**WALBERTON PARISH COUNCIL
INCLUDING FONTWELL AND BINSTED**
Parish Council Office, The Pavilion, The Street,
Walberton, Arundel, West Sussex, BN18 0PJ

30 November 2020

Planning application WA/79/20/PL – Spindlewood, Yapton Lane, Walberton.

At a recent Planning Committee Meeting, Walberton Parish Council resolved to OBJECT to the above planning application on the grounds detailed below.

Drawing.
Proposed Site Plan

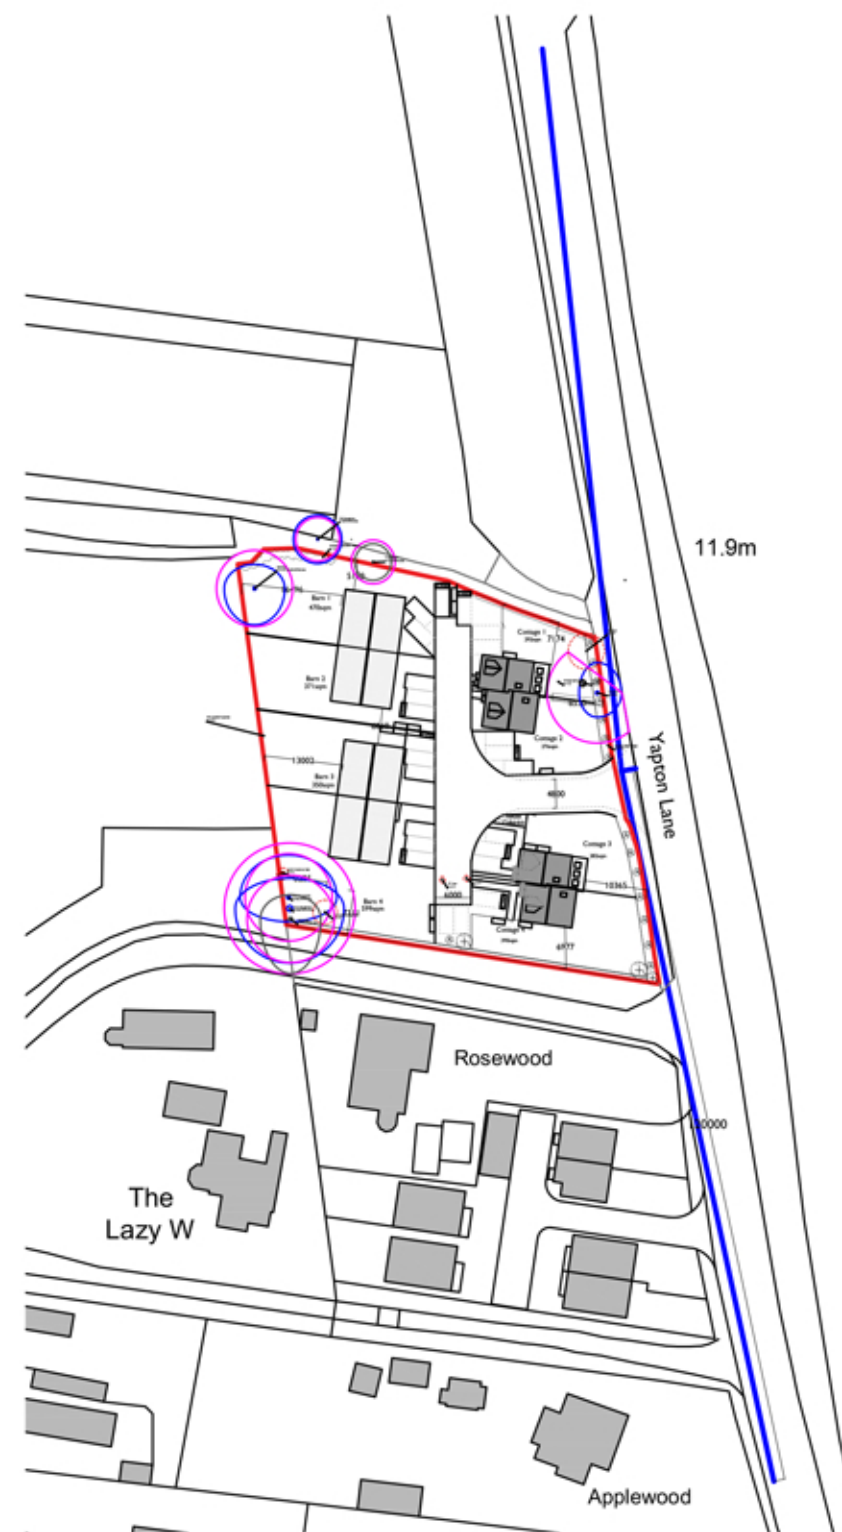
The site has had previous applications refused (WA/33/18/OUT and WA/30/20/PL) and is not listed in HELAA. The latest plans have very much the same layout. While the buildings have been moved a little bit, the density and orientation are unchanged and still contrary to Arun Local Plan policies D DM1 and QE SP1. The proposal would result in the increased use of travel by the motor car as the local area is not safe for pedestrian and cycle movements contrary to policy T SP1 of the Arun Local Plan.
